Application by North Somerset District Council for Portishead Branch Line – MetroWest Phase 1
The Examining Authority’s written questions and requests for information (ExQ1)
Issued on 26 October 2020

2.42 - Pill Station Car Park and PSP Layout, Landscaping Lighting and Access Plan

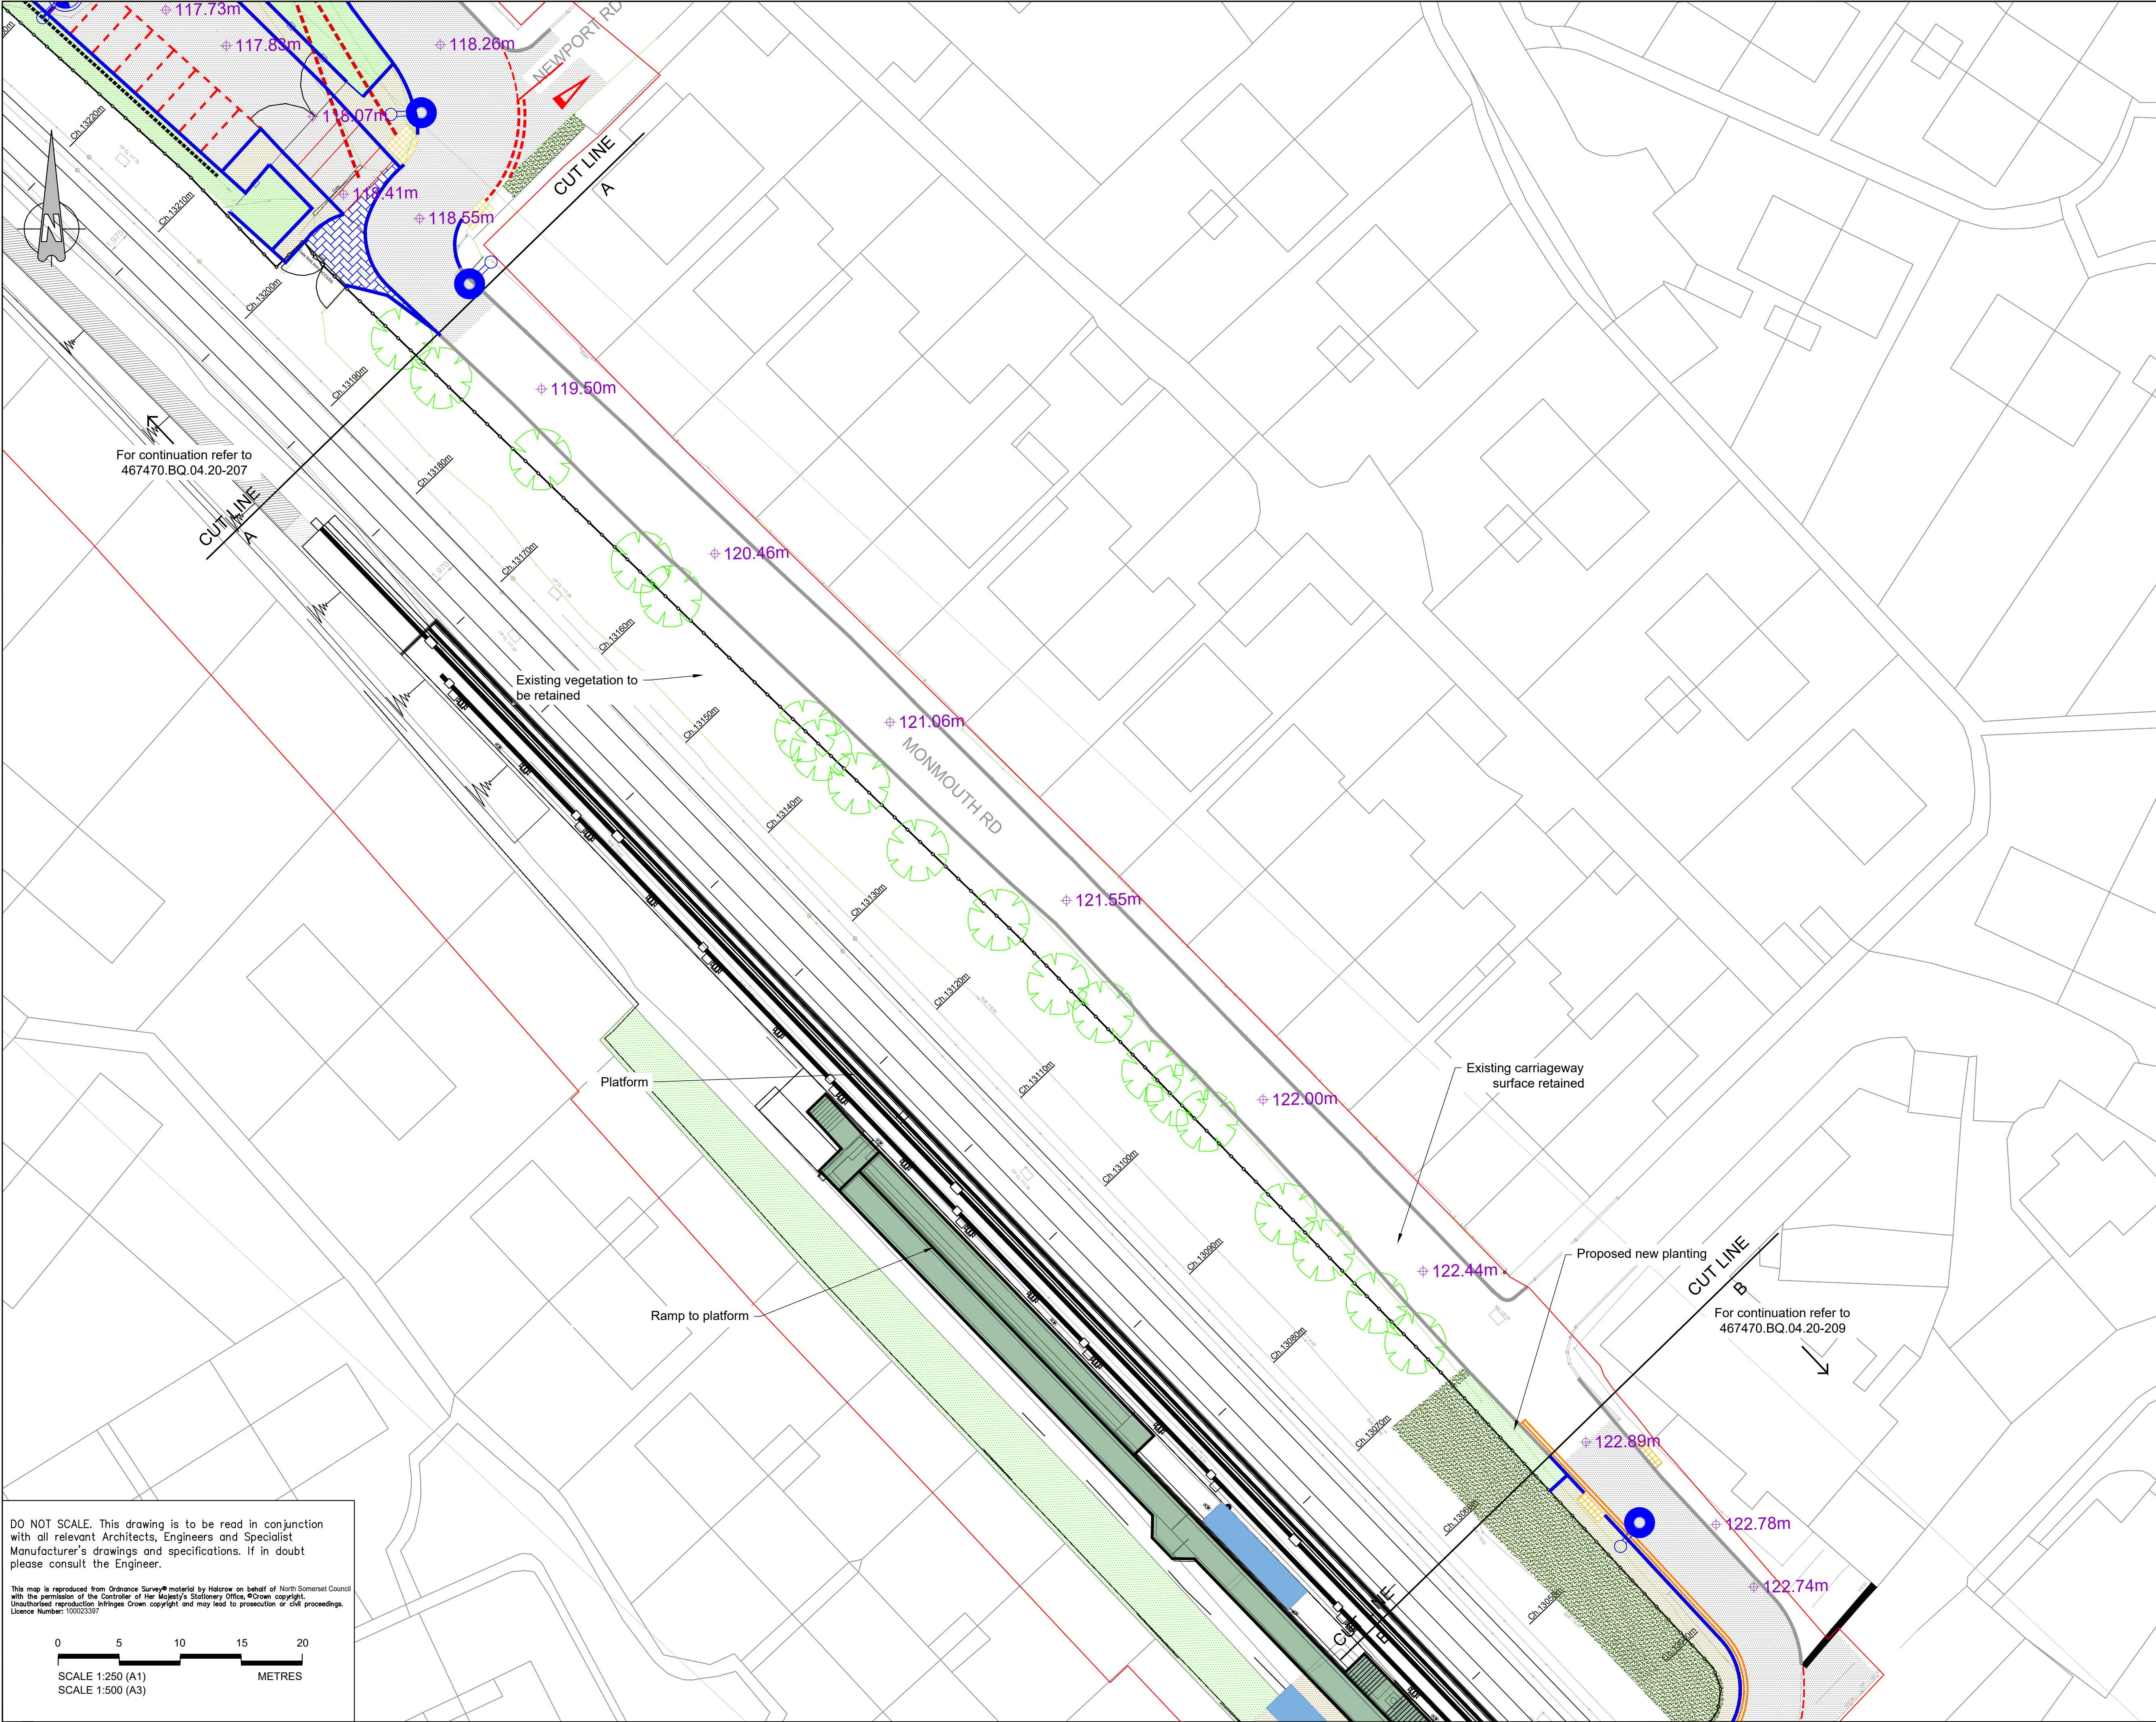
ExQ1	Question to:	Question
BIO.1.36	<i>Great Crested Newts</i> The Applicant	Planting of scrub and long grass at Pill Station for newt habitat is shown on Pill Station Car Park plan [APP-038] but is not referenced in the dDCO - how would adherence with this plan be secured?
BIO.1.37	<i>Wildlife Corridor</i> Bristol Port Company The Applicant	<p>Whilst on our Unaccompanied Site Inspection [EV-001] the ExA observed the existence of a wildlife corridor adjacent to Royal Portbury Dock that is managed/ owned by the BPC.</p> <p>BPC: Provide further detail of the wildlife corridor including why it is provided, what animals use it, how long it has been in existence and any plans/ maps to show the extent of the corridor.</p> <p>The Applicant: Signpost where in the application documentation the effect of the proposed development on this wildlife corridor has been considered and if it hasn't, why not.</p>
